Fisheries Management and Mitigation Strategy

This Fisheries Management and Mitigation Strategy (FMMS) has been updated in response to Item 12 (Commercial Fisheries) of the Applicant's further information request (FIR) received from An Coimisiún Pleanála (the Commission) on 1st August 2025. This version of the FMMS (Rev 01) supersedes the previous revision (Rev 00) that was included with the CWP Project planning application.

In summary, the updates within this version of the FMMS are limited to the following sections:

Drawing file: 09. Planning Drawings / Planning Drawing 0063 Export cable burial and protection details Revision B.pdf

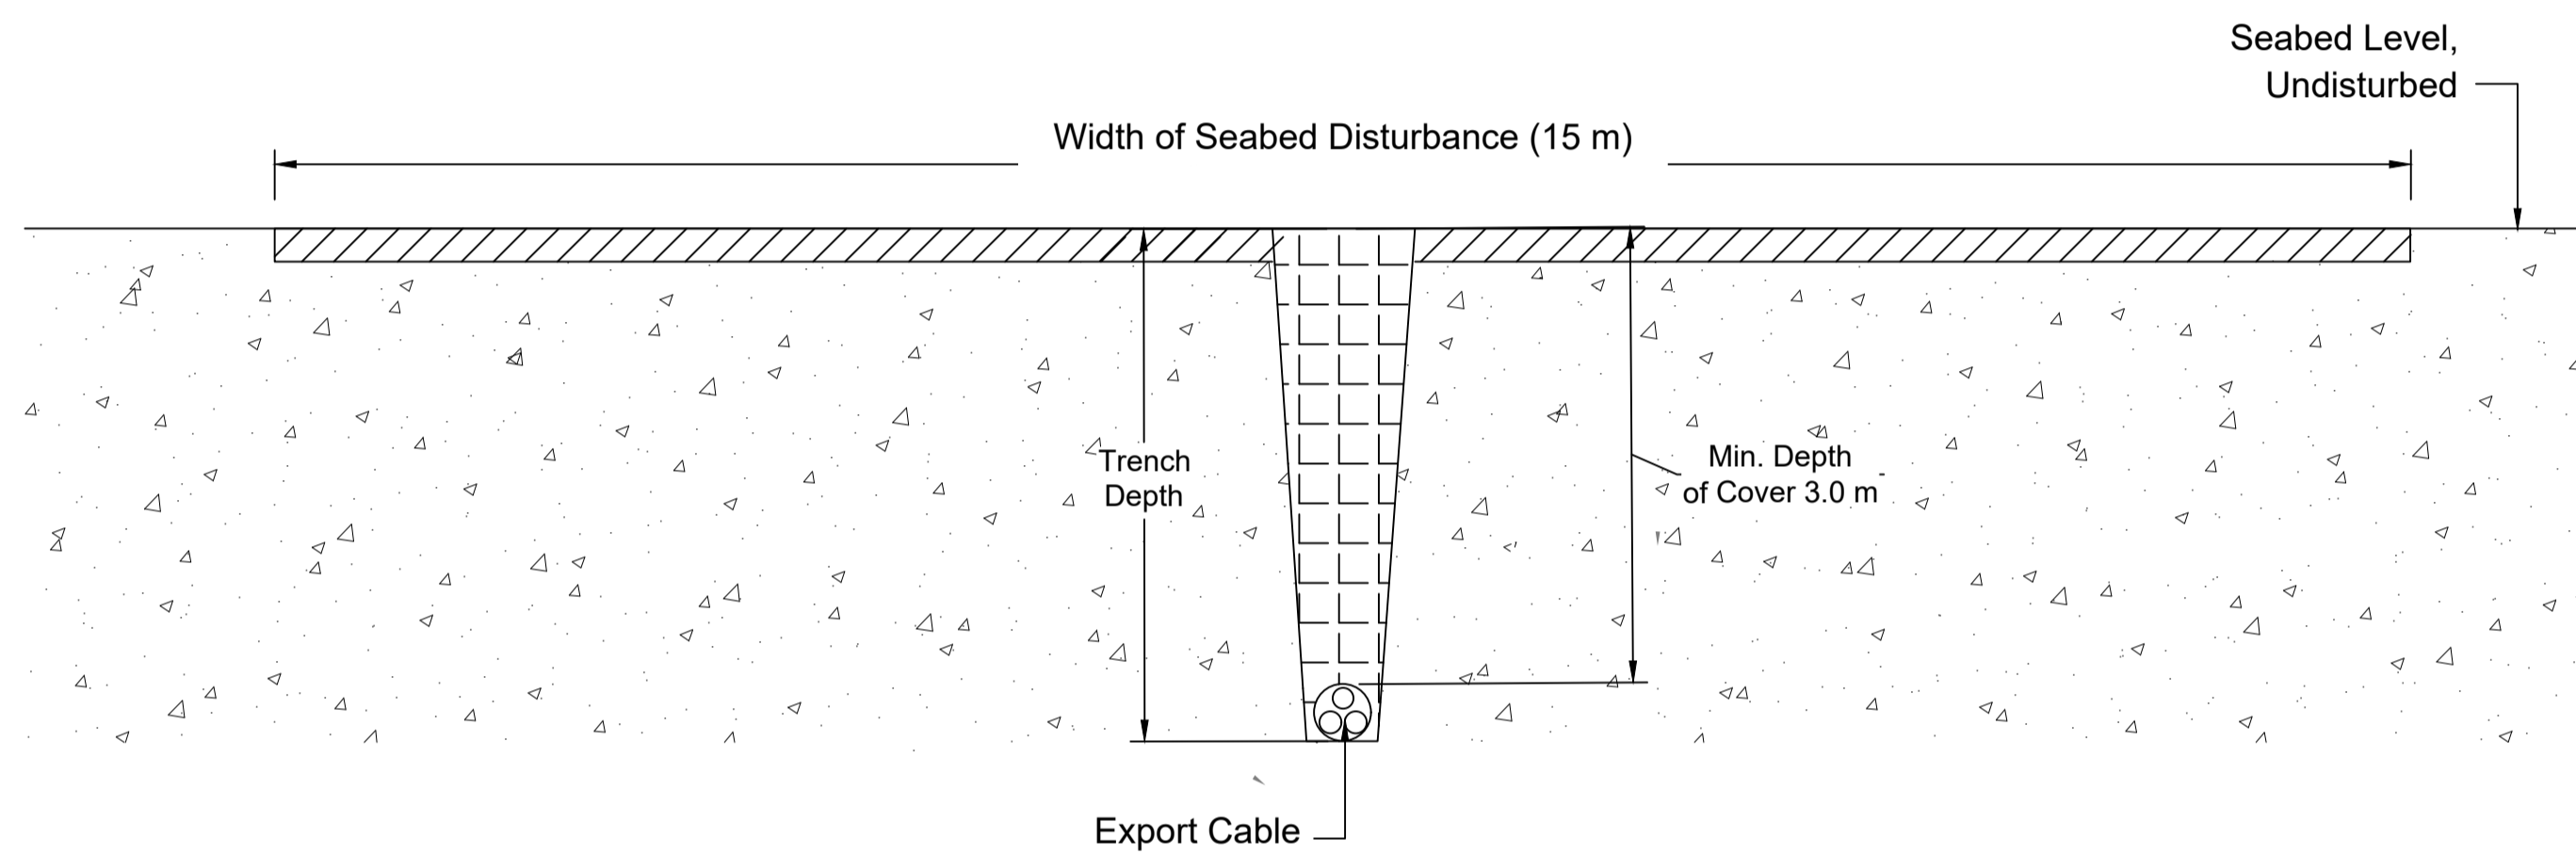
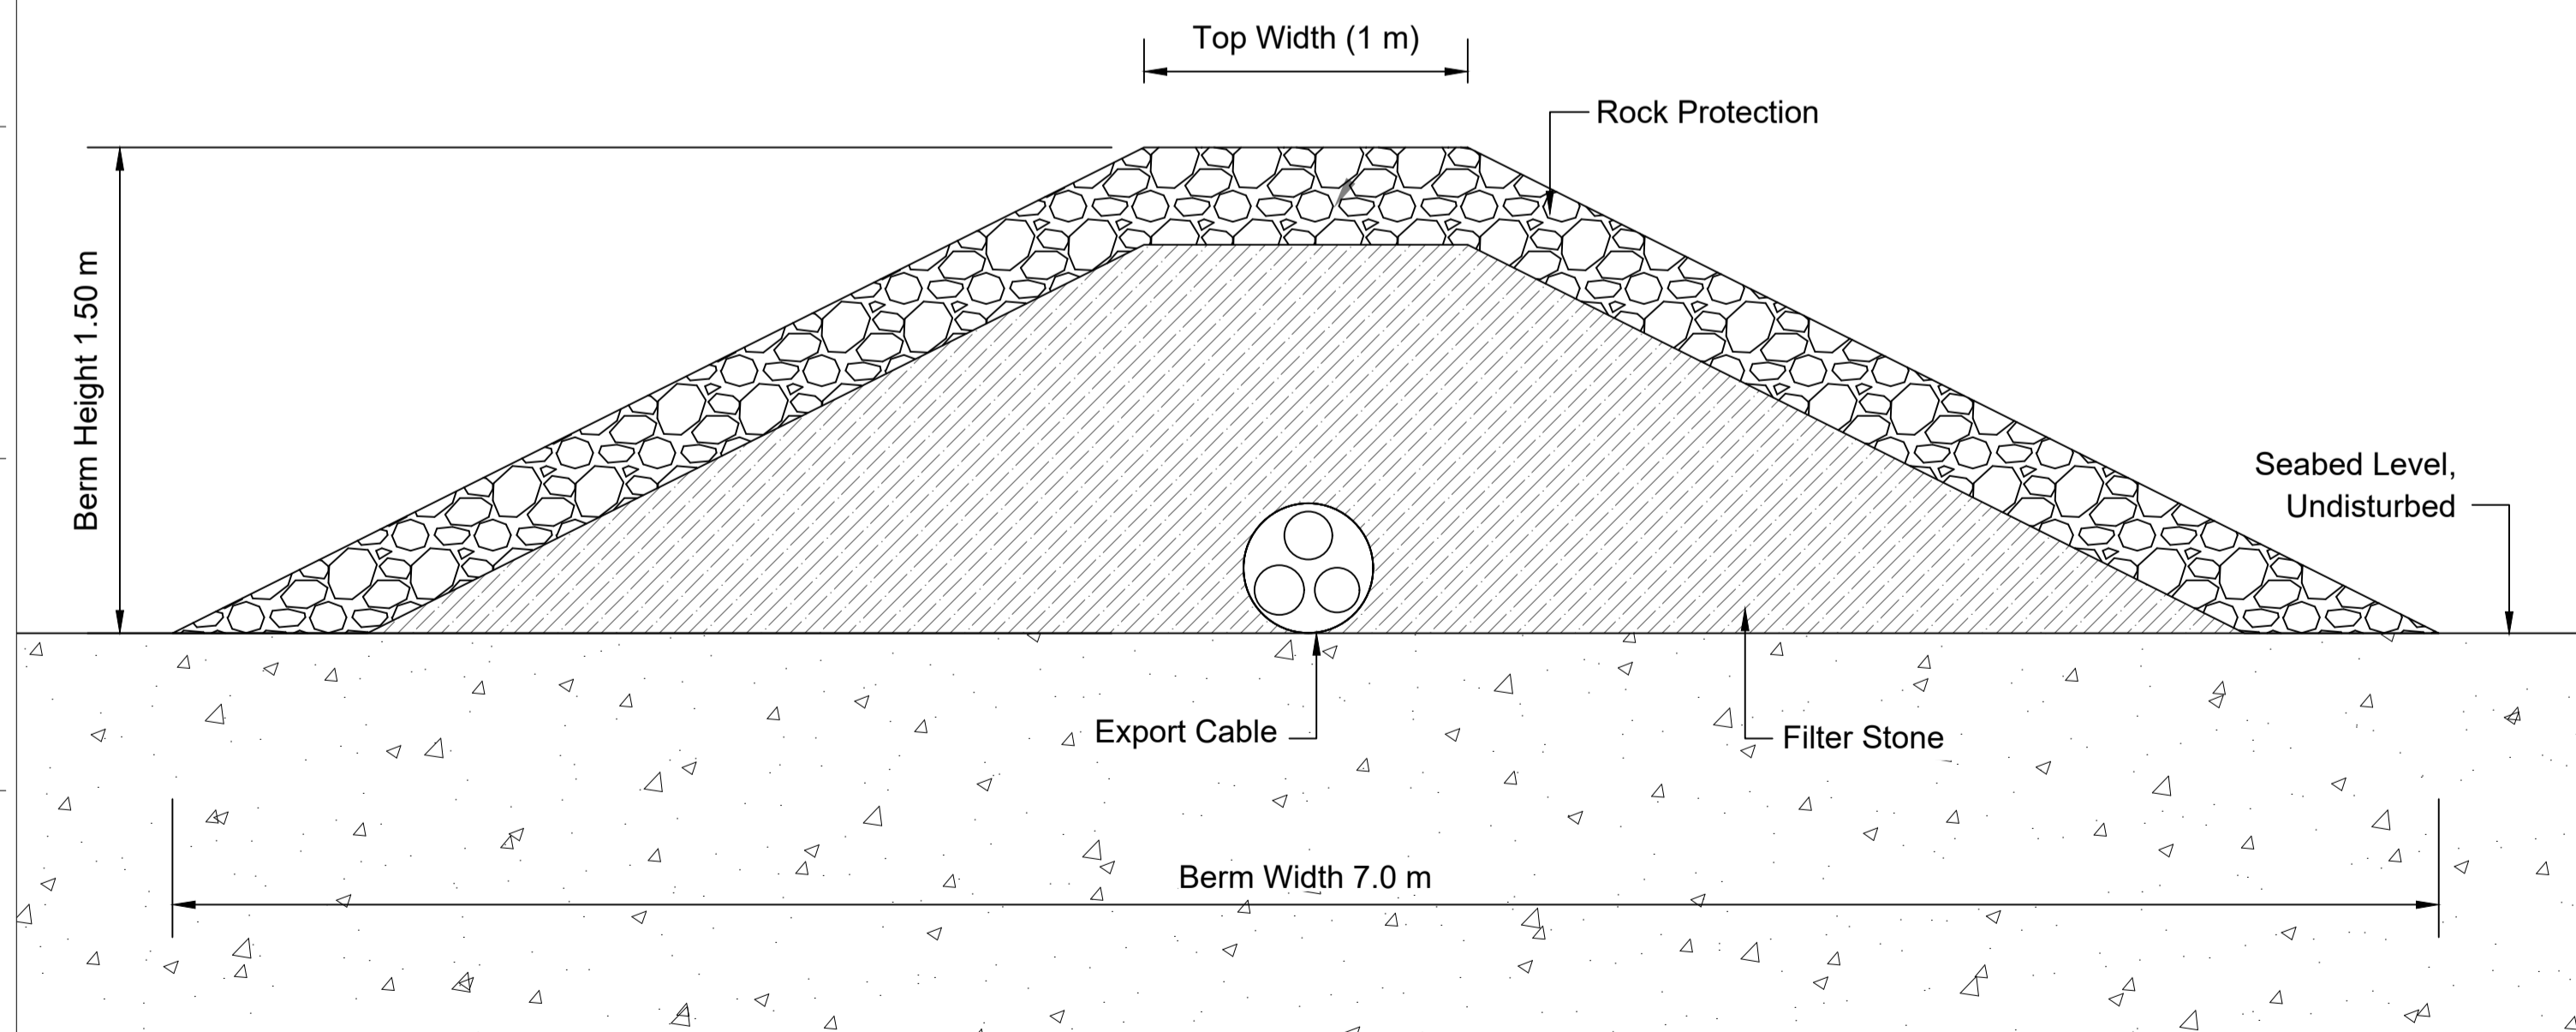
Section 2.5 is unchanged except for paragraph 35 which is replaced by paragraph 35 below. This update has been made in response to FIR Item 18a (see [FIR Response Document](#)).

35. The Developer will, where practicable, bury all IACs and interconnector cables to a minimum depth of cover of 1 m. Likewise, the Developer will bury all offshore export cables within the OECC to a

minimum depth of cover of 1.4 m (except cables buried within the zone of greater burial depth adjacent to Dún Laoghaire (DL) Harbour, which will have a minimum depth of cover of 3.0 m).
